**FLYING HORSE NORTH FILING NO. 5**  
**PRI #2, LLC.**  
 EL PASO COUNTY, CO

**GRADING & EROSION CONTROL PLAN**  
 INITIAL & INTERIM GEC

**SHEET GEC 3**

SHEET GEC 3

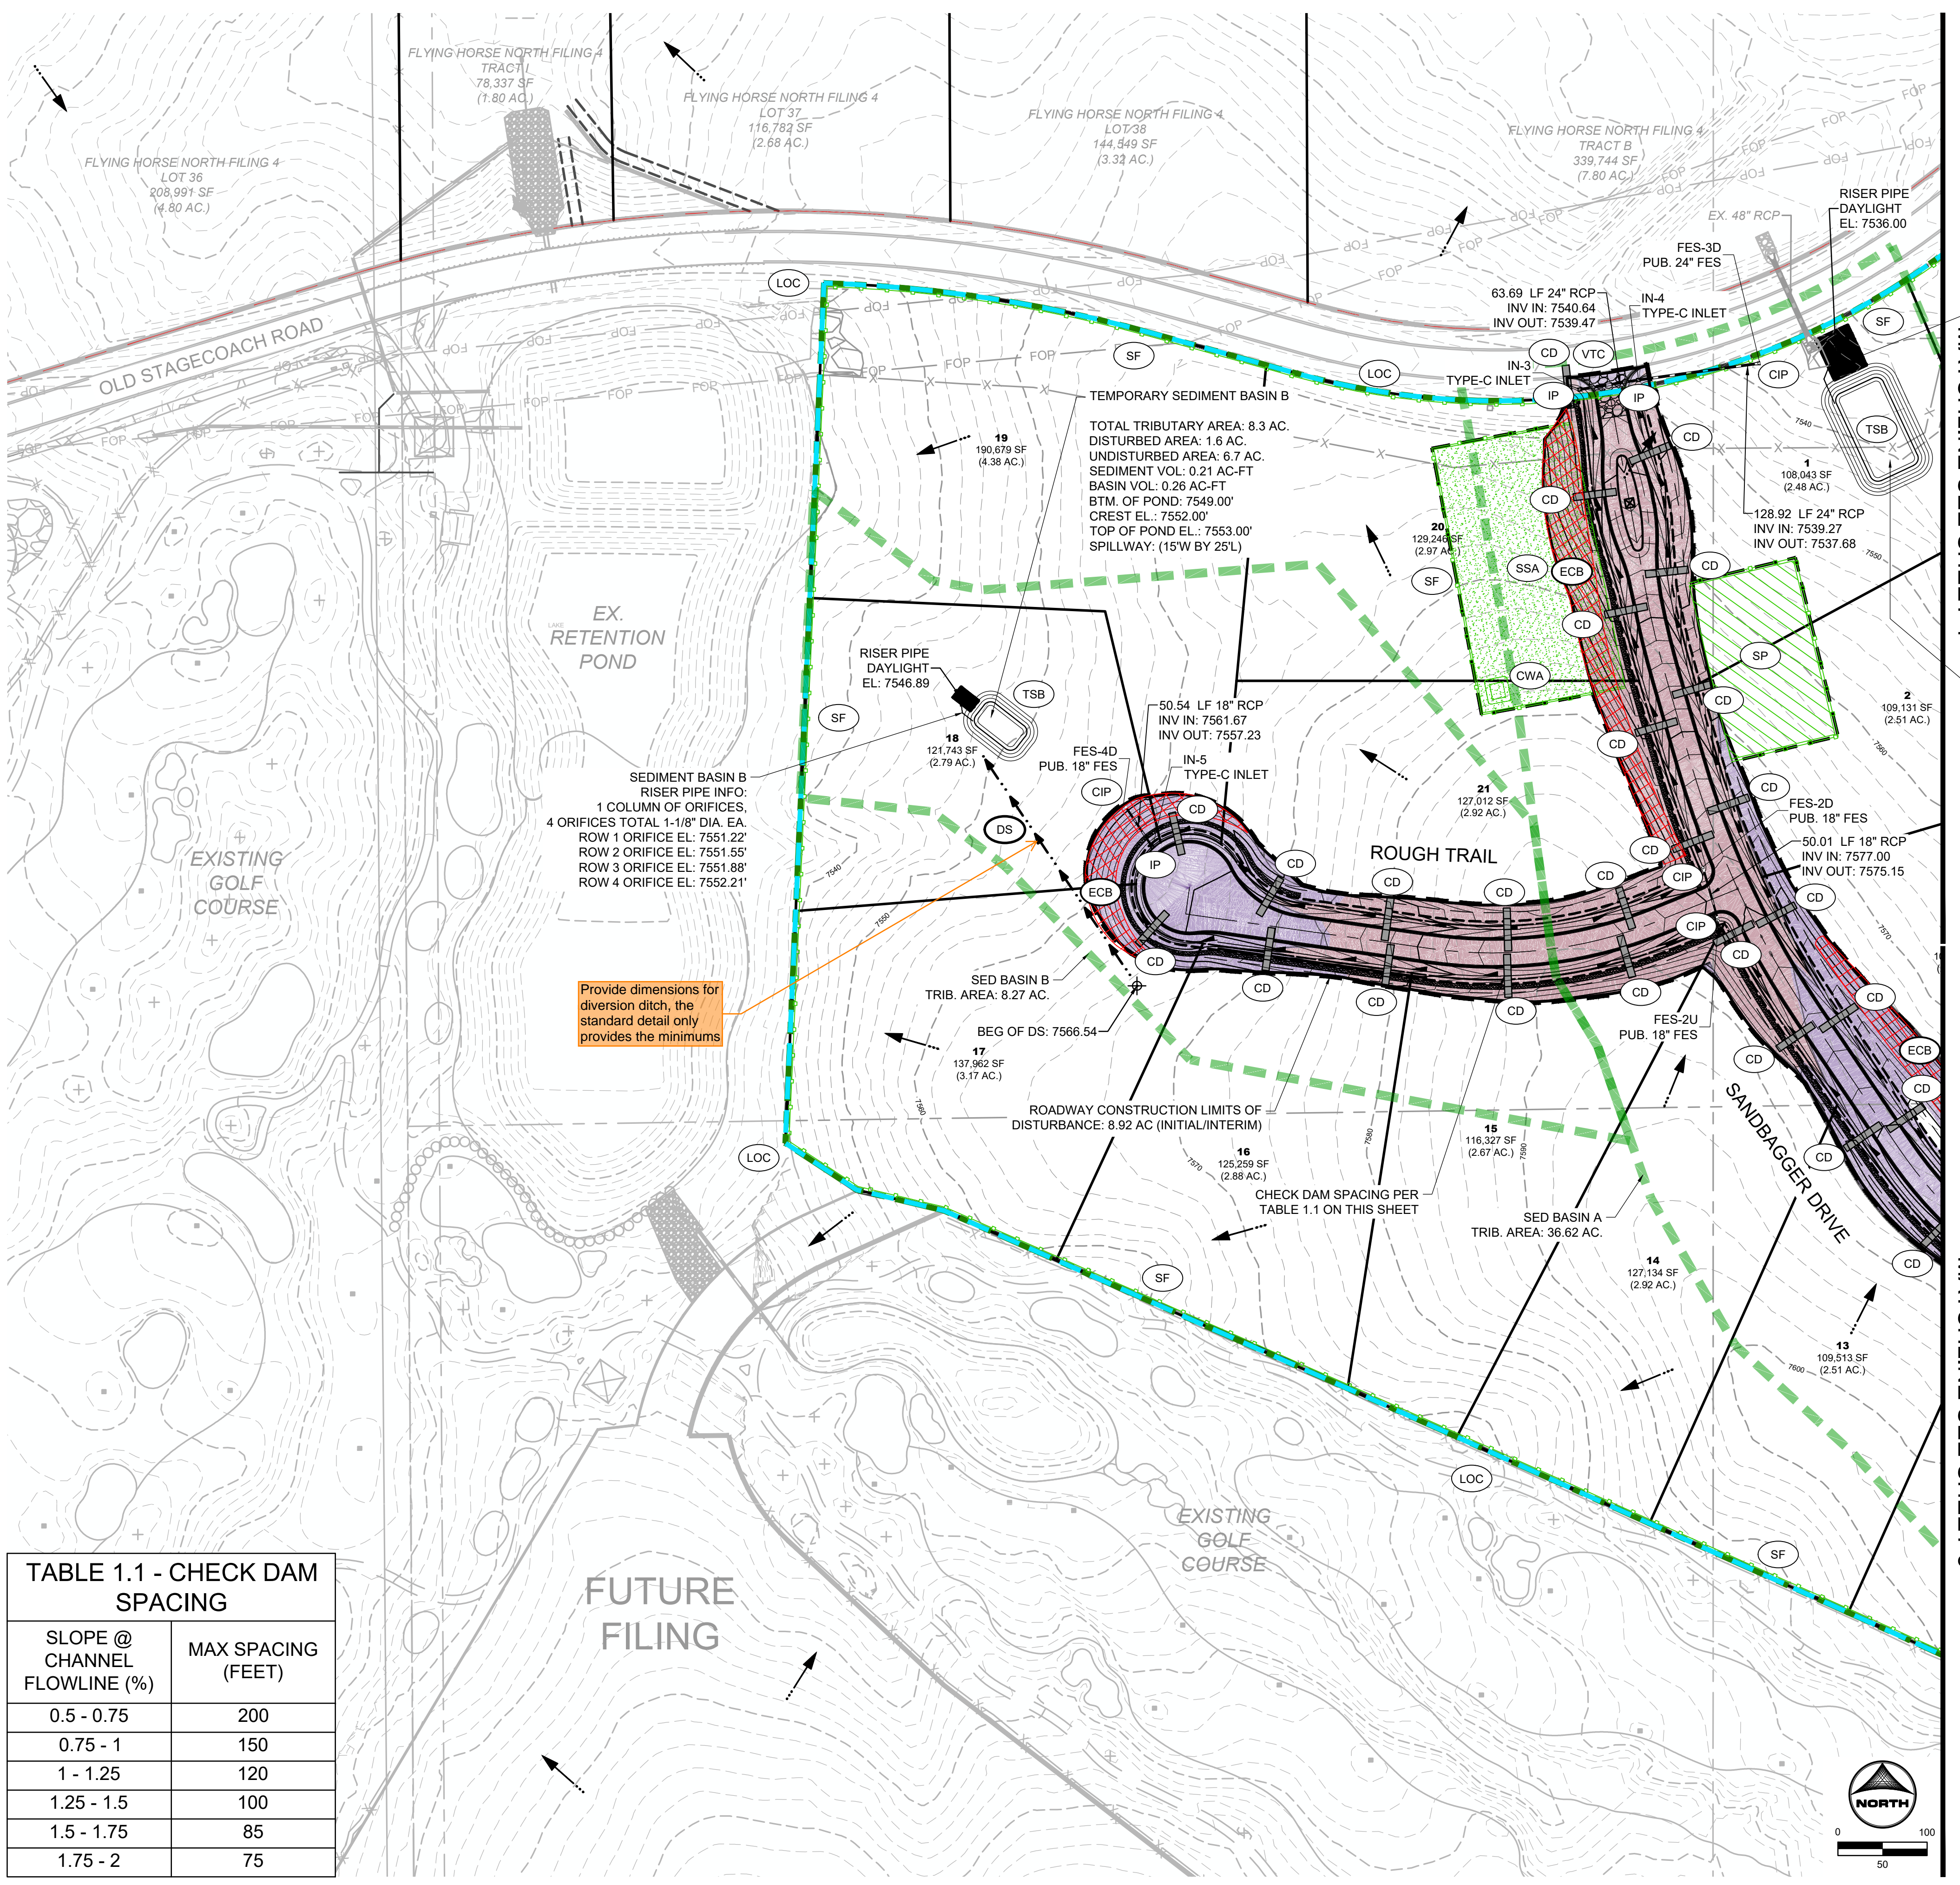
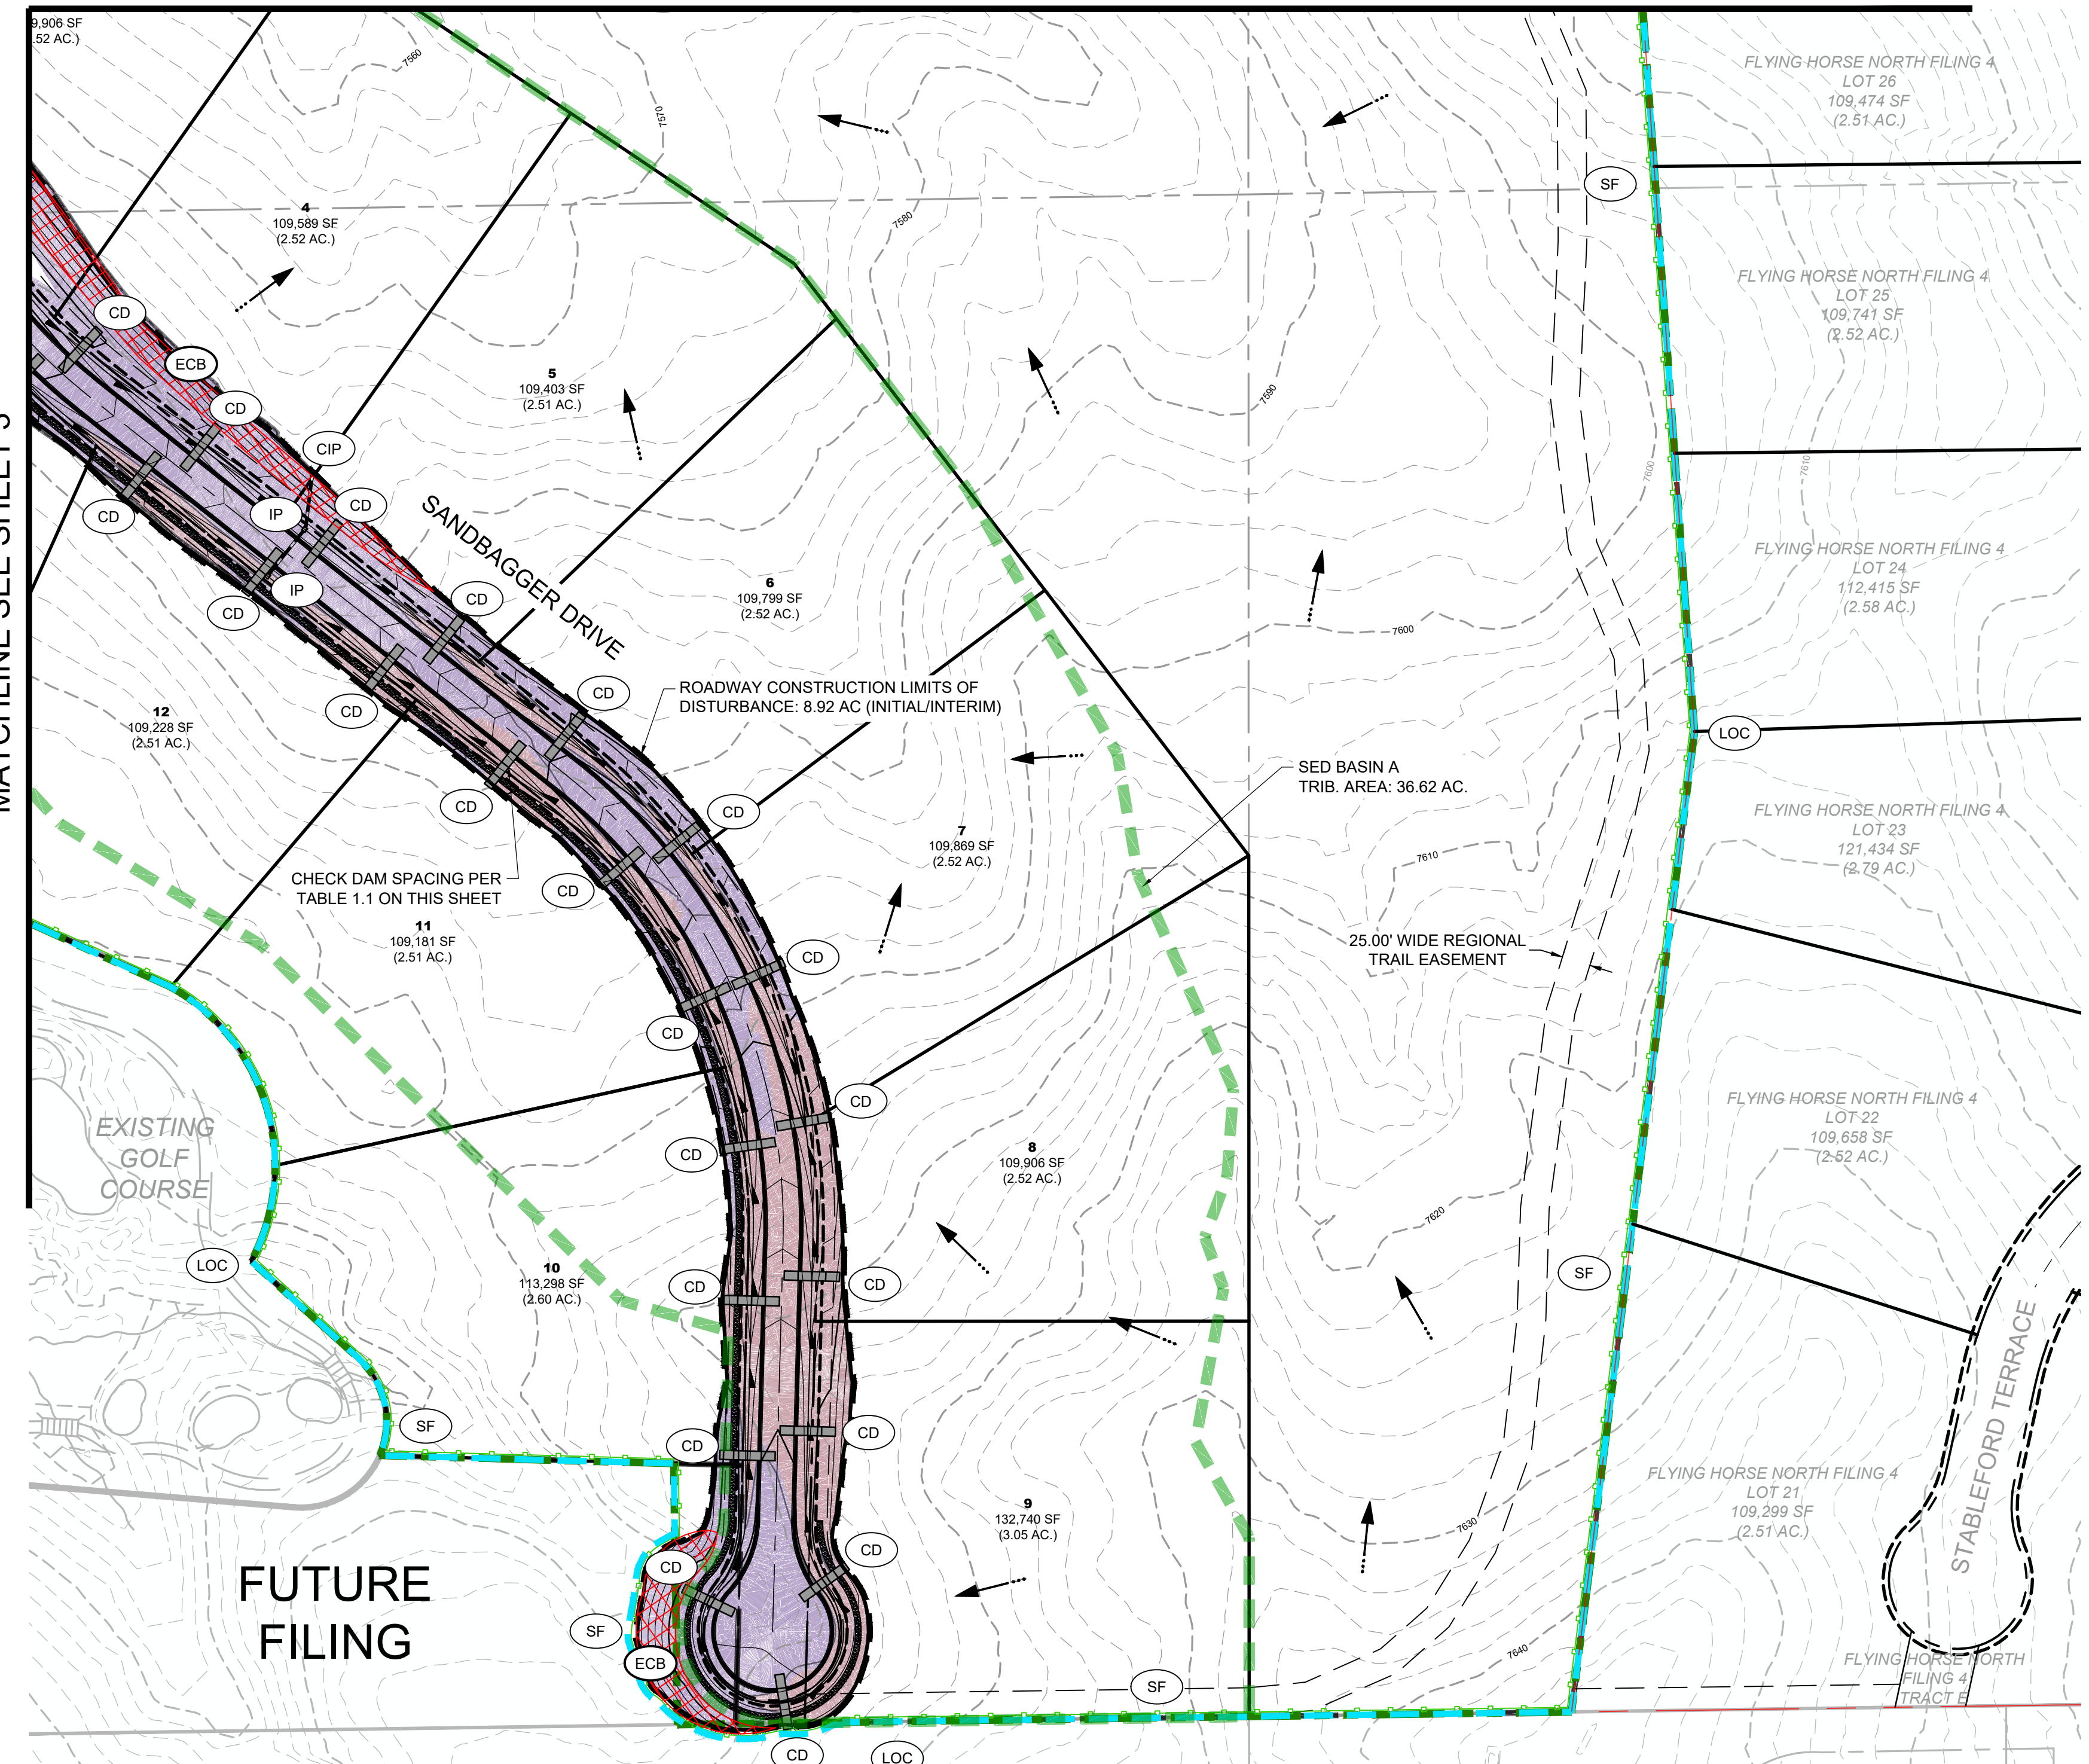
GEC Checklist Item bb - clearly label the two existing permanent stormwater management facilities that are treating the project site.

Provide more contour labels so it is easier to verify elevations.

Provide dimensions for diversion ditch, the standard detail only provides the minimums

**HRG RESPONSE:**  
LINEWORK AND LABELS ADDED FOR EXISTING STORMWATER FACILITIES.

**HRG RESPONSE:**  
ADDITIONAL CONTOUR LABELS PROVIDED.

**HRG RESPONSE:**  
TEMPORARY DRAINAGE SWALE DIMENSIONED.
